From: Contact Centre (CRM) <contact@ribblevalley.gov.uk>
Sent: 13 March 2026 14:23
To: Planning
Subject: Planning Application Comments - 3/2026/0021 FS-Case-811928961

Planning Application Reference No.: 3/2026/0021

Address of Development: 41 - 43 Wellgate Clitheroe

Re: 3/2026/0021 - Change of use of upper floors to create four flats and external alterations - 41-43 Wellgate Clitheroe BB7 1LU

SHEET:
Existing and Proposed
sections with details

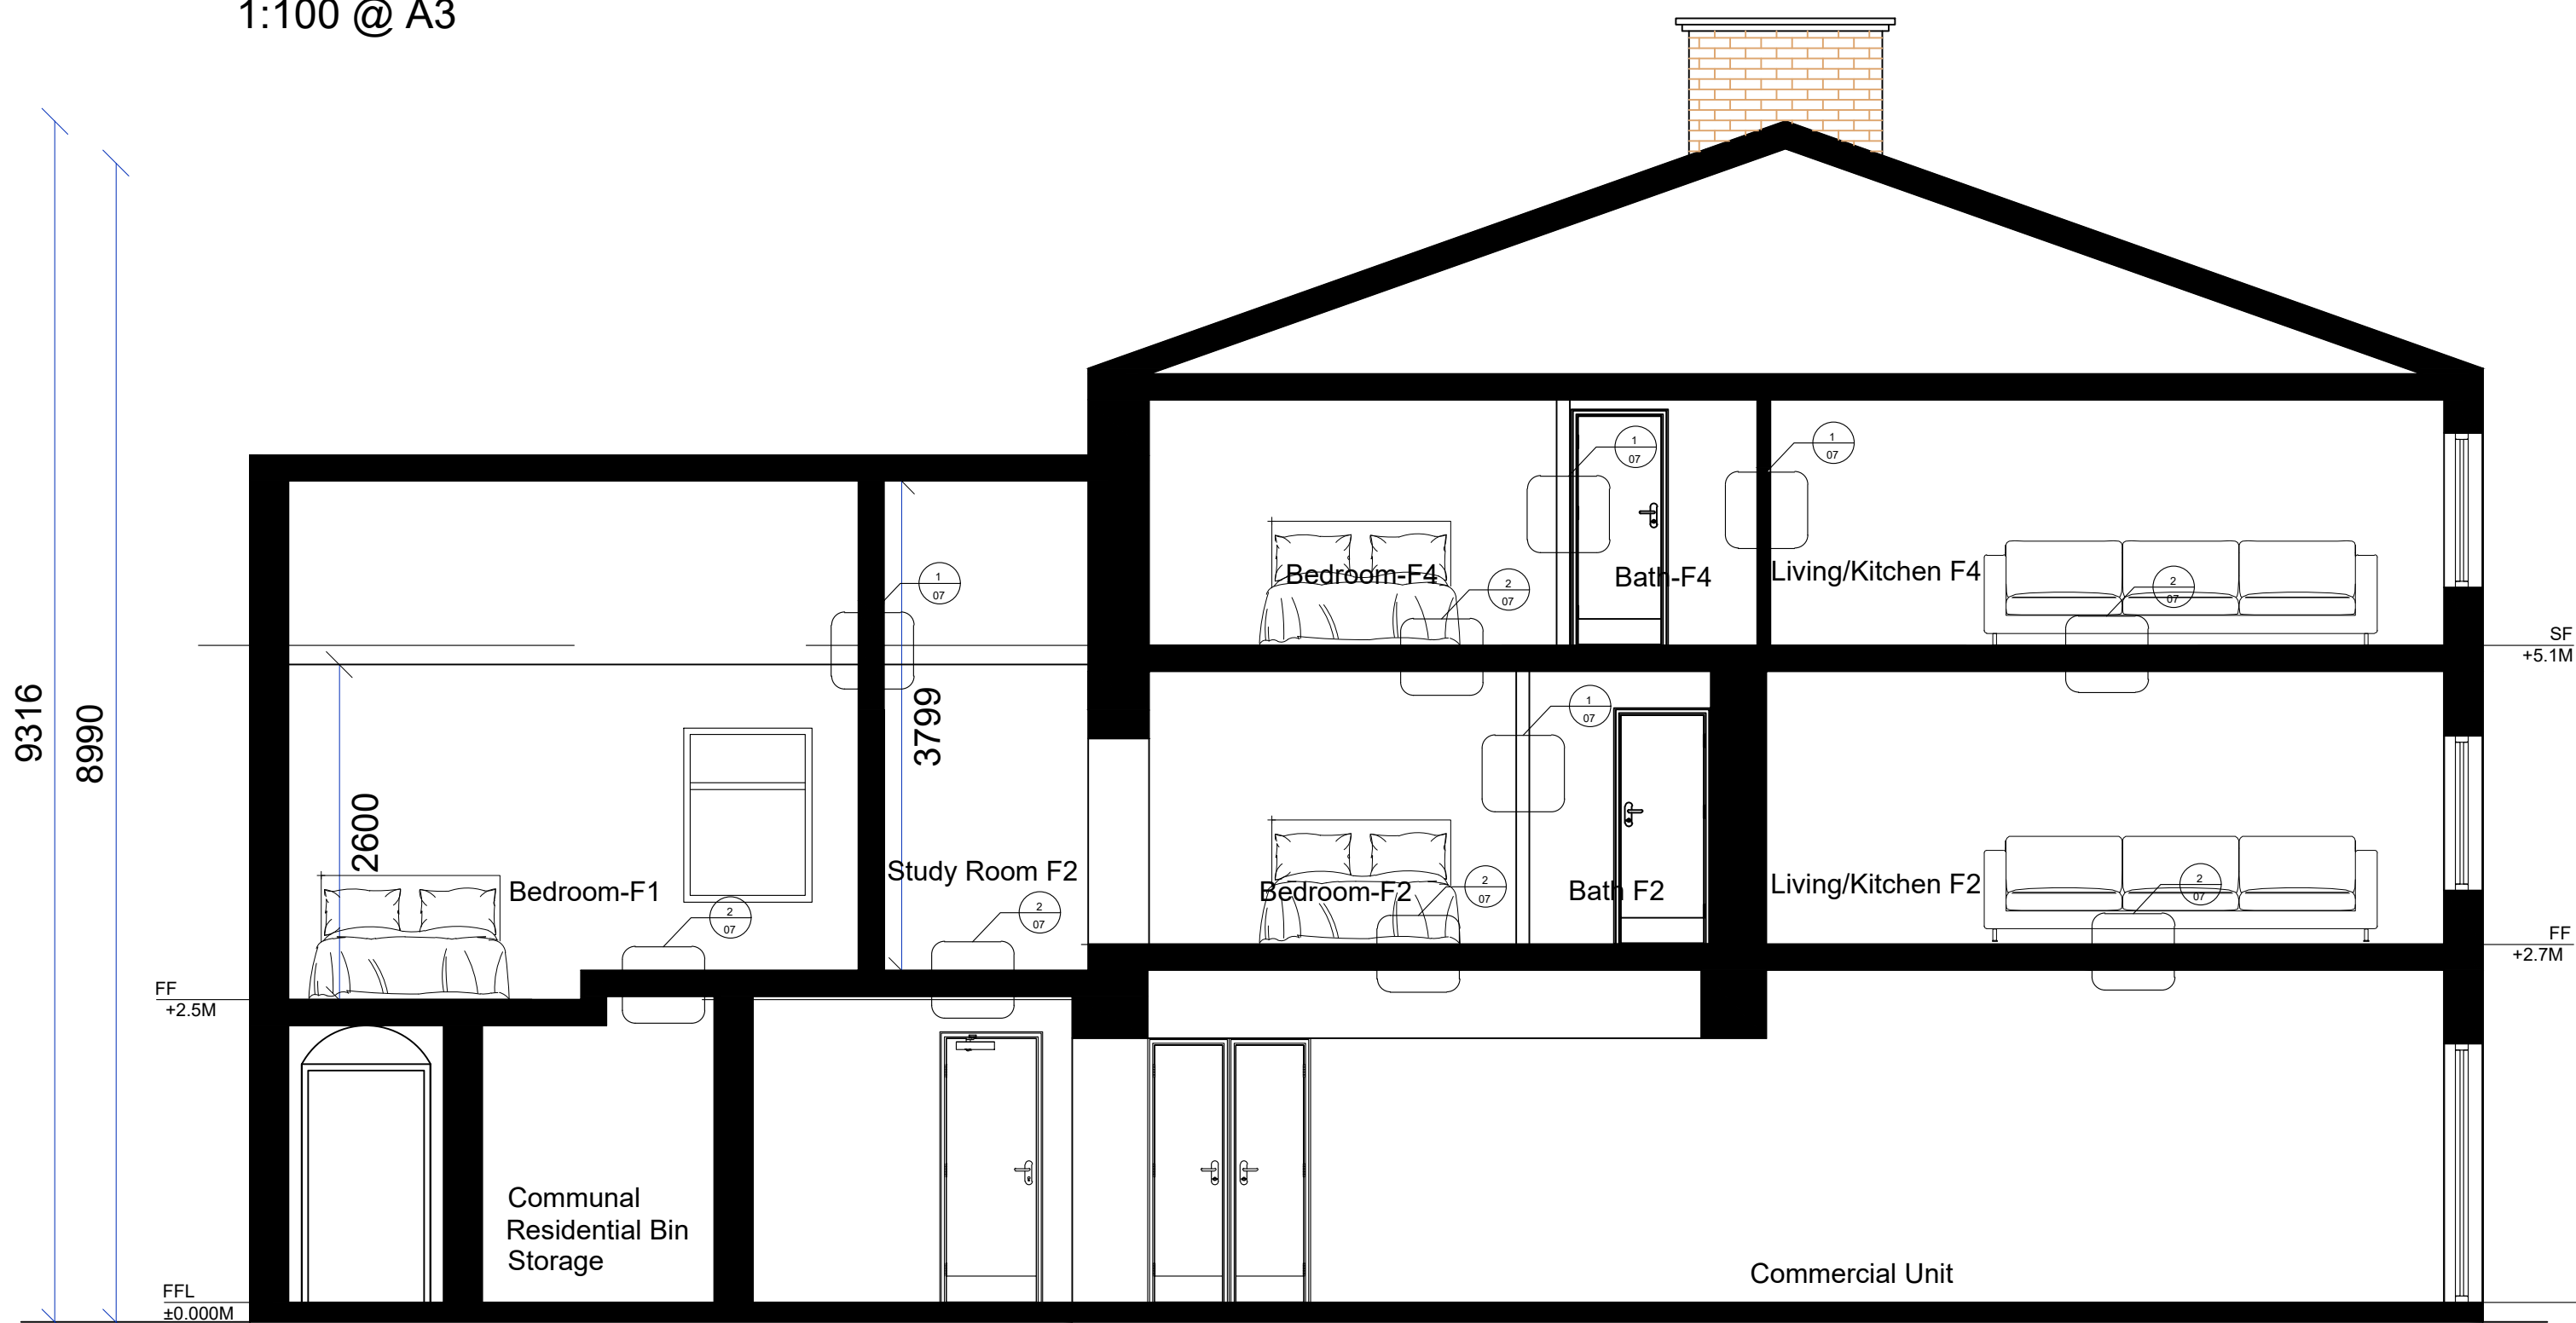
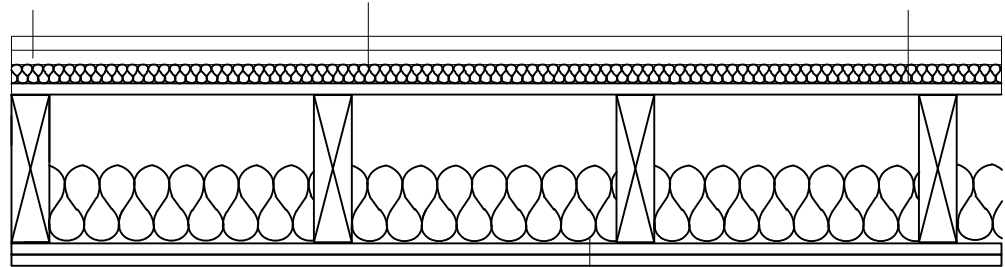
Details in the application regarding upgraded soundproofing for the building state that new stud walls, ceilings and built-up floors would contain aqua resistant or cement boarding. Additionally, ceilings and floor edges would be taped and sealed.

It is understandable that additional measures will be needed to soundproof the building, however consideration should be given to the breathability of materials used and whether these will be suitable for a traditionally constructed solid-walled building. The Acoustic Assessment states that windows will generally be closed, and that additional ventilation provision must be made for the property however there are no further details of this in the application. Ventilation to ensure vapour permeability is very important for the long-term preservation of buildings such as this, to avoid condensation leading to deterioration and rot of floor and roof joints where they meet the external walls.
